Preliminary Report on Metrolink Route and its Potential Effect on AerCap House

Waterman Moylan Consulting Engineers Limited

Client Name: Hines
Document Reference: 22-117r.101
Project Number: 22-117

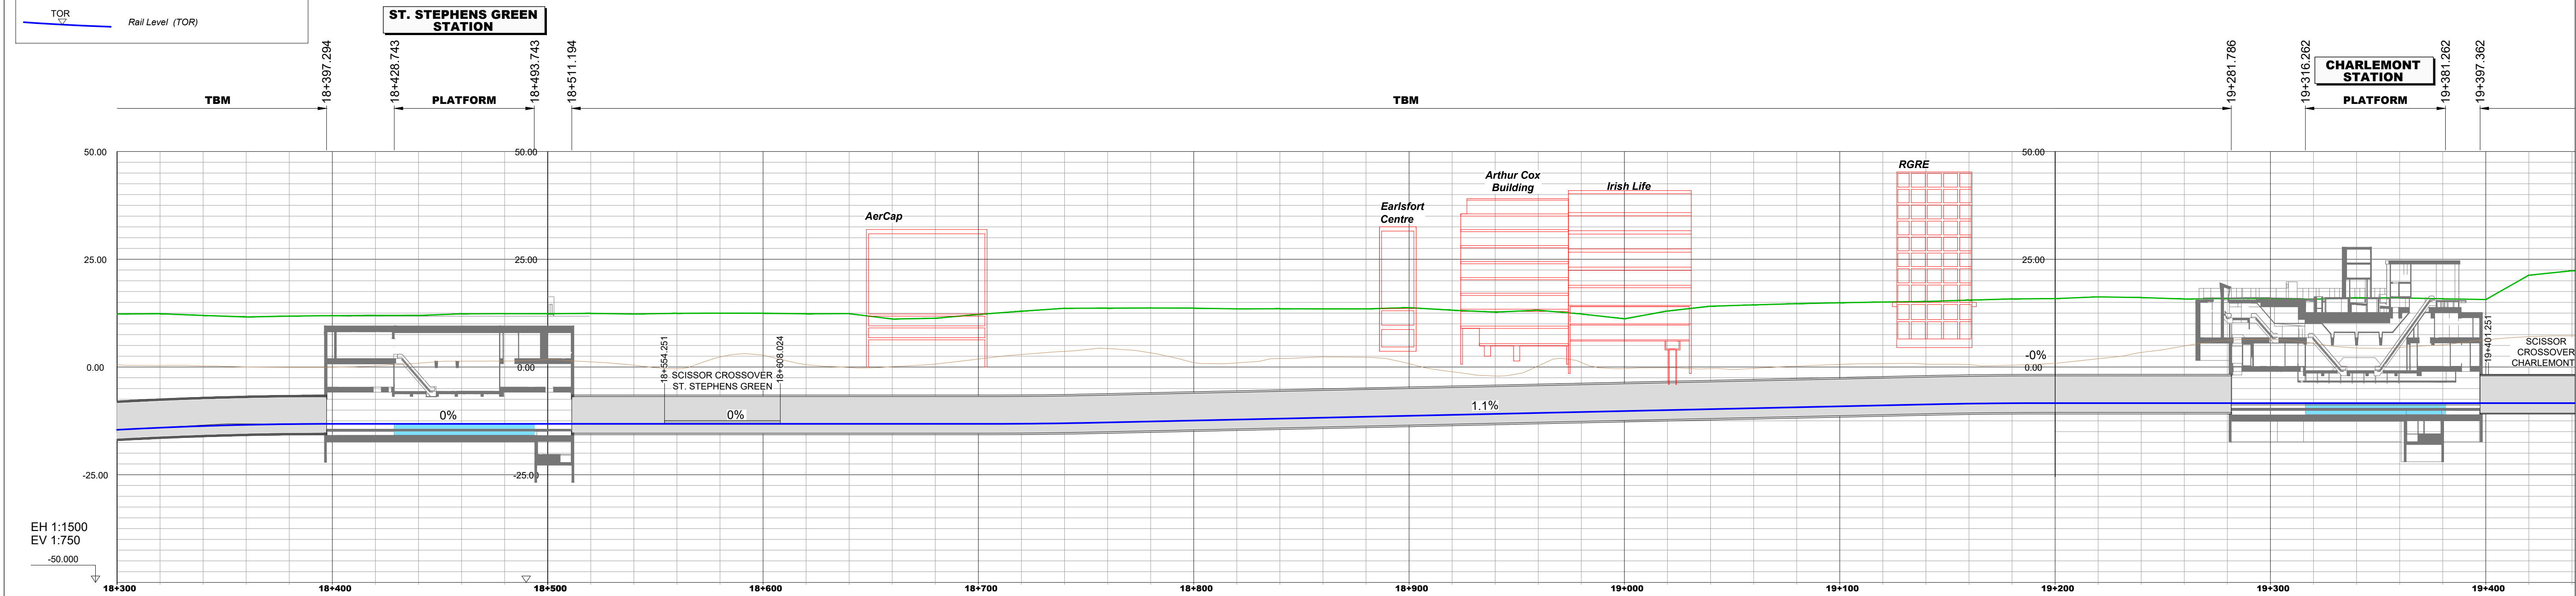
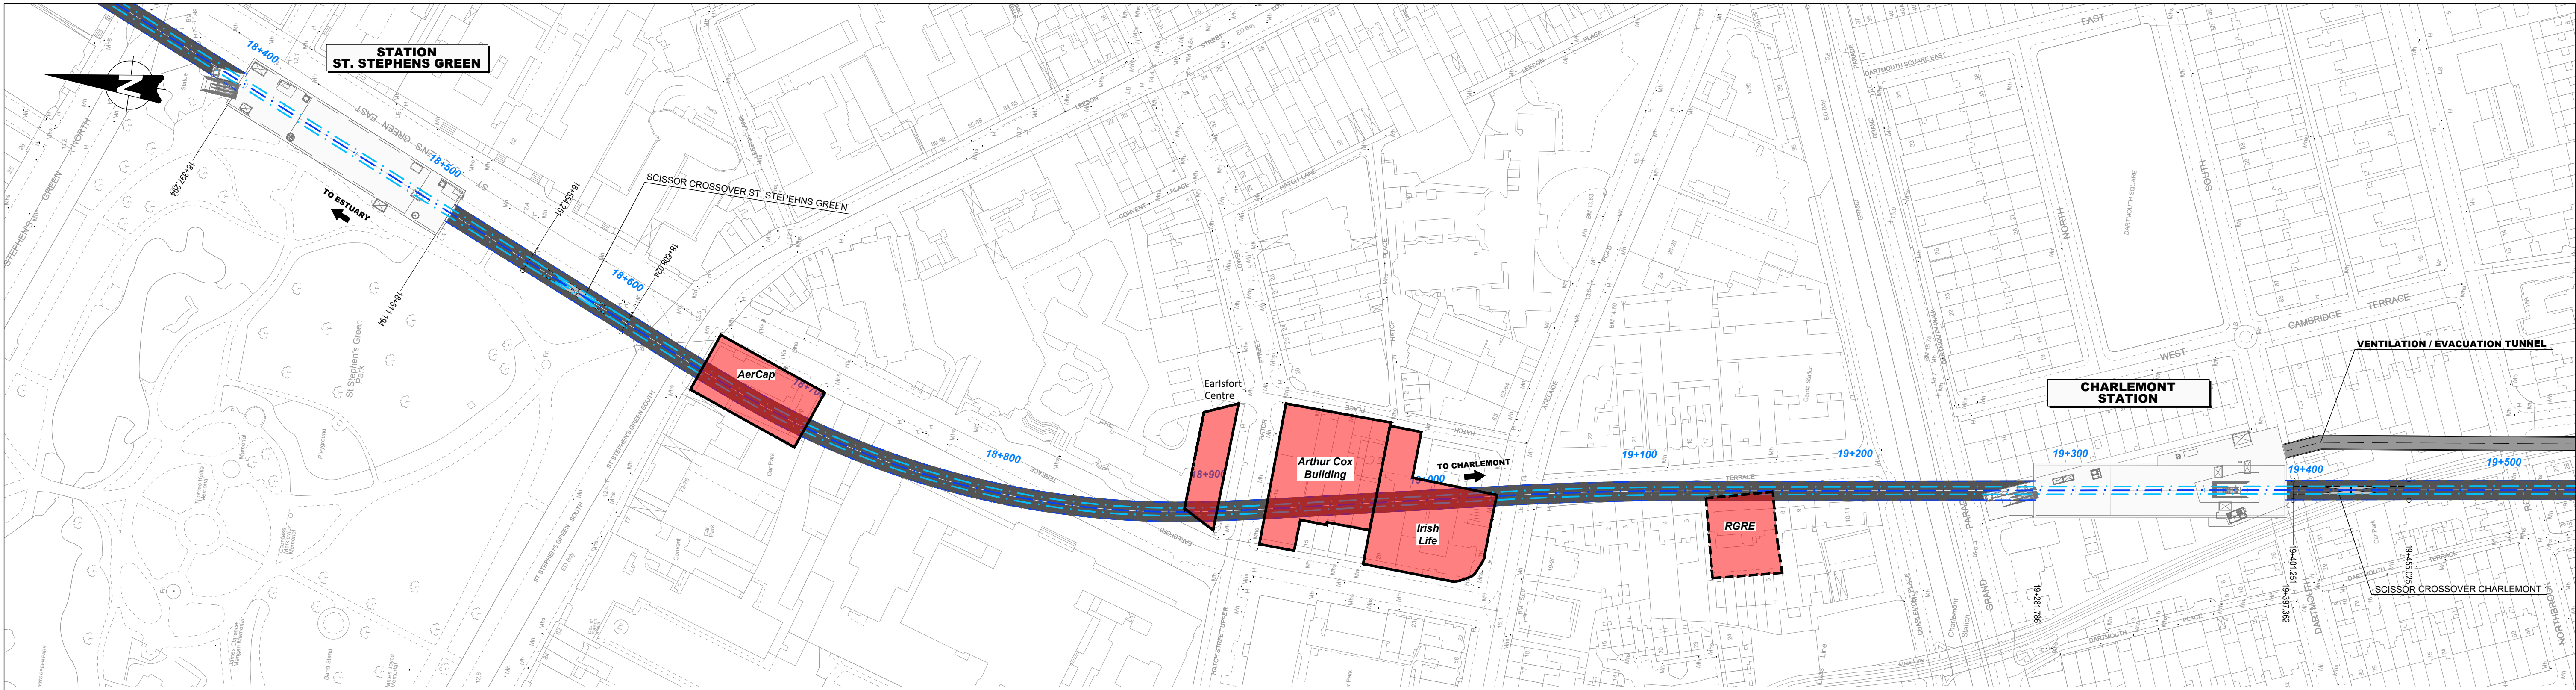
The proposed Route of the Metrolink tunnel passes under AerCap House, entering at the southern boundary and exiting at the northern boundary. The level of the proposed Metrolink rail varies between c. -13.180m AOD at the southern boundary and c. -13.200m AOD at the northern boundary. Based on the information in the Metrolink Rail Order, we understand the outside diameter of the tunnel to be 9.2m and that the cutting diameter of the proposed Tunnel Boring Machine ("TBM") is 9.53m. We note that the final diameter of the TBM is to be left to the discretion of the contractor and could be larger than currently presented by Jacobs/IDOM.

We have added the relevant information Exclusion Zones, and Limits of Deviation to Jacobs/IDOMs drawing number ML1-JAI-ARD-ROUT_XX-DR-Y-01018 included in Appendix B of this Report. We have also indicated the location and volume of the substructure and superstructure of AerCap House.

Based on the overlay, it is clear that the substructure to the basement is located at the top of the exclusion zone as presented DOC ML1-JAI-GEO-ROUT_XX-RP-Y-00034.

A detailed Phase 3 assessment using the correct building geometry and structural form should be completed and independently verified, ensuring the maximum damage caused to AerCap House is limited to 0.1mm cracking. The proposed tunnel elevation may require to be lowered more than the current LOD downwards, i.e. more than the 10.0m indicated in the Wider Effects Report submitted as part of the application, considering the proximity and sensitivity of AerCap House.

Figure 11: Bored Tunnel Protection and Exclusion Zones

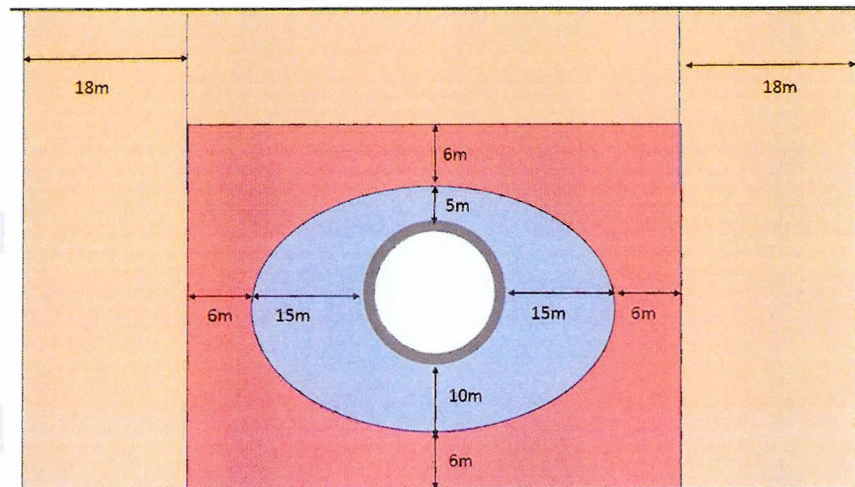
We have reviewed the "Draft Guidance Note For Developers" document dated May 2023, which was submitted at the beginning of the Oral Hearing. In section 2.1.4 Tunnels, Figure 11: Bored Tunnel Protection and Exclusions Zones is presented indicating the exclusion zone to the tunnel extending 5.0m above the top of the tunnel and 10.0m below the bottom of the tunnel. There is also a lateral exclusion zone, which is 15.0m on either side of the tunnel.

We understand that AerCap House could not have been developed in its current form had the Metrolink Tunnel been previously constructed, as there are substructure elements required to extend into the exclusion zone, which could cause damage to the Metrolink Tunnel.

As the Metrolink Tunnel is a significant piece of infrastructure and has been designed to resist significant earth pressures, it is equally likely that such a significant piece of structure could cause damage to the existing substructure elements of AerCap House that are currently in place and providing support to AerCap House.
